Recommendation: Approve

Applicant: Heyford Park Settlements LP

Proposal: Reserved matters to 10/01642/OUT - Dorchester Phase 7A, comprising the provision of eleven, two bed affordable dwellings with associated landscaping, car parking, infrastructure and external works.

DRAWING TITLE: EXTERNAL WORKS
DRAWING NO: 0521-PH7A-104

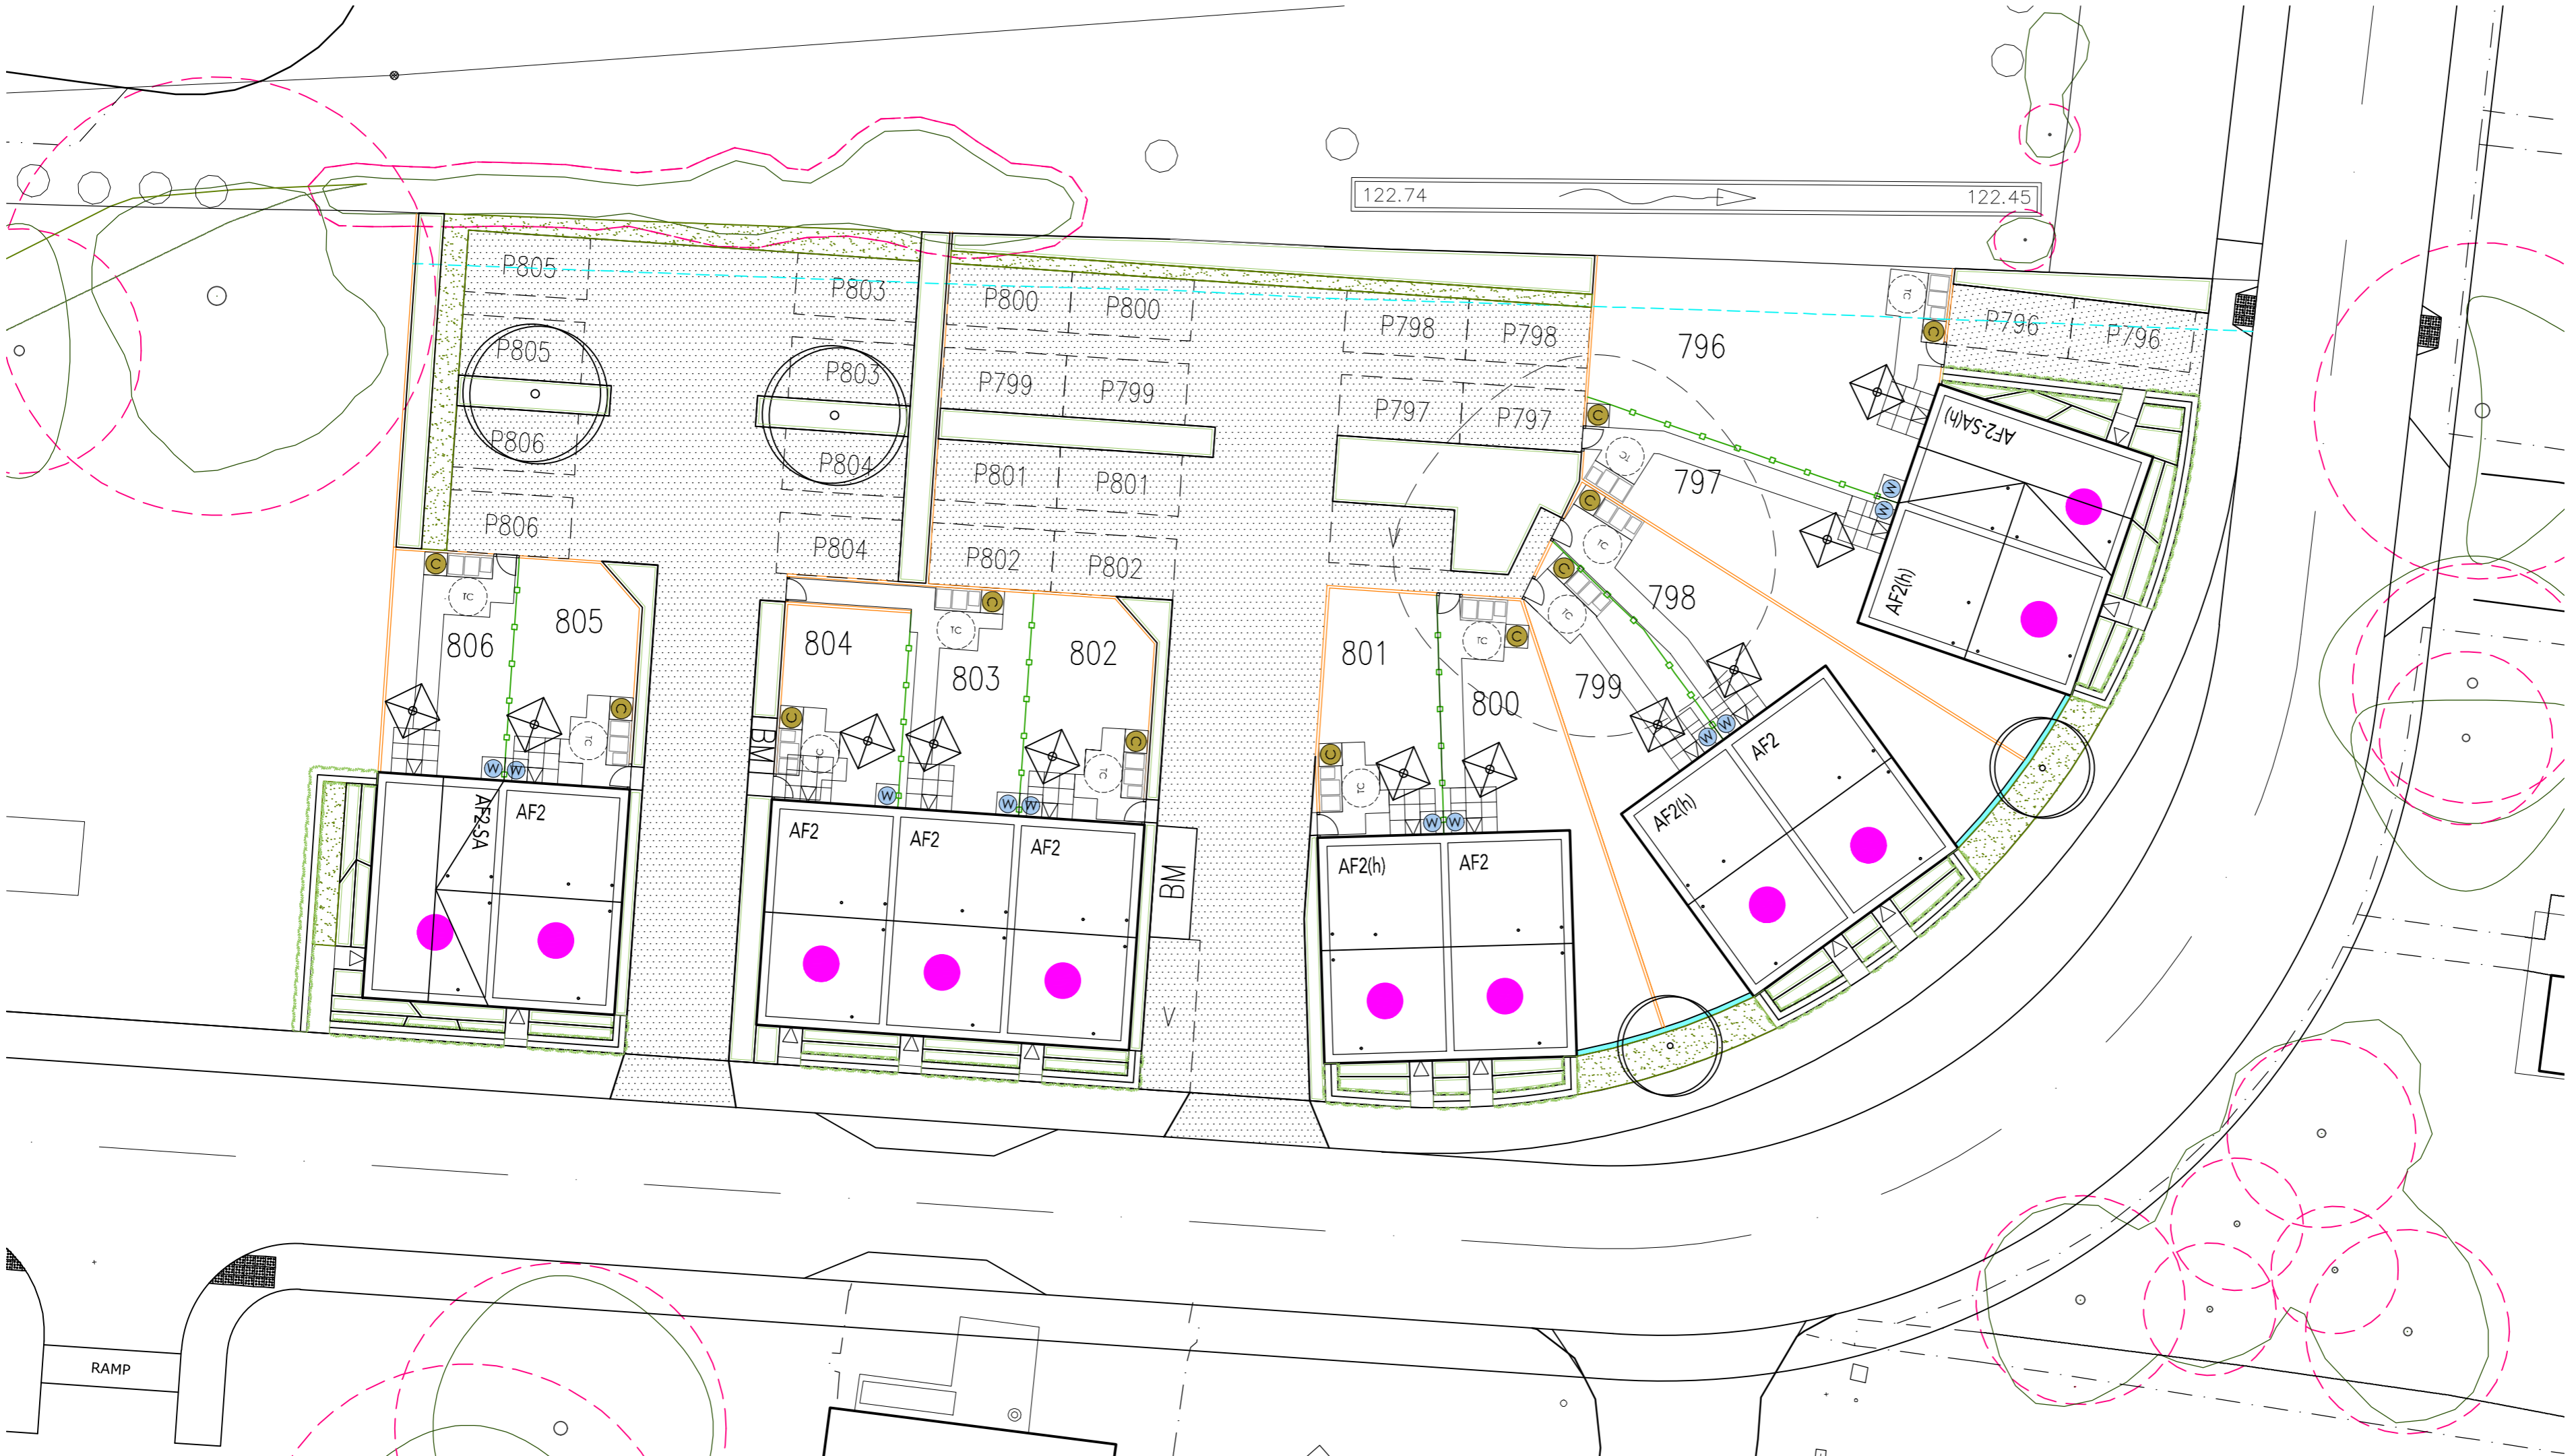
Response received, objection. Clarification is sought regards to whether the proposal would represent an overall increase in the housing numbers above those approved by application 10/10642/OUT. Concern is raised regarding the parking spaces adjacent to plots 796, 801 and 802. There is concern that there are insufficient details regarding the refuse collection for plots 796-800, 803 and 806. It is advised that it may be possible to secure these clarifications, by condition.

- 8.29. Whilst it is noted that Oxfordshire County have objected on the grounds that clarification should be sought with regards to the total housing numbers, vision splays from parking spaces and refuse collections, it is considered that these matters can be resolved through the imposition of conditions as recommended by the Highways Officer.
